County of Bernalillo
State of New Mexico
Public Works Division

Subject: Bernalillo County Regional Recreation Complex (BCRRC), Mesa del Sol Traffic Impact Study

Below are Bernalillo County comments on the subject draft TIS dated April 18, 2022. Please address these comments for the subsequent submittal.

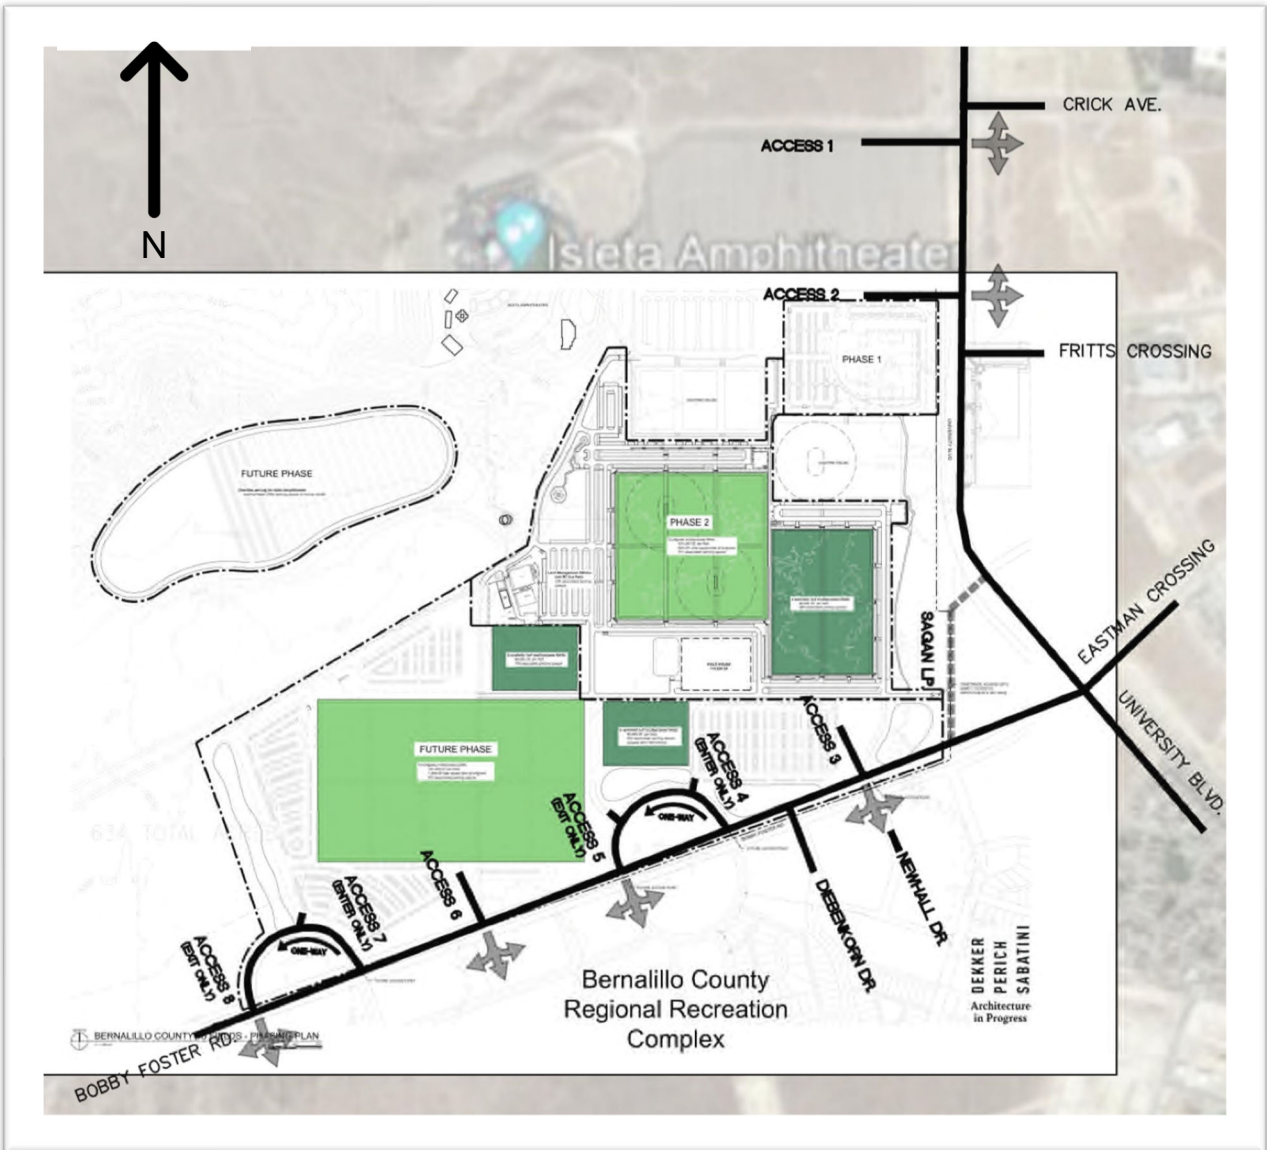
1. Page iv (Vicinity Map), Page 3, A-2 (Site Plan) – Please provide a legible image where the 1-3 phases and the associate generators (fields or offices) can be seen on the map. There is conflicting information on the site plan with symbology showing Access 5 & 8 as full access, but notes stating that each is either exit or enter only. The pages detailing each intersection provide images of this site plan with incorrect access arrows. These pages need to updated as well.
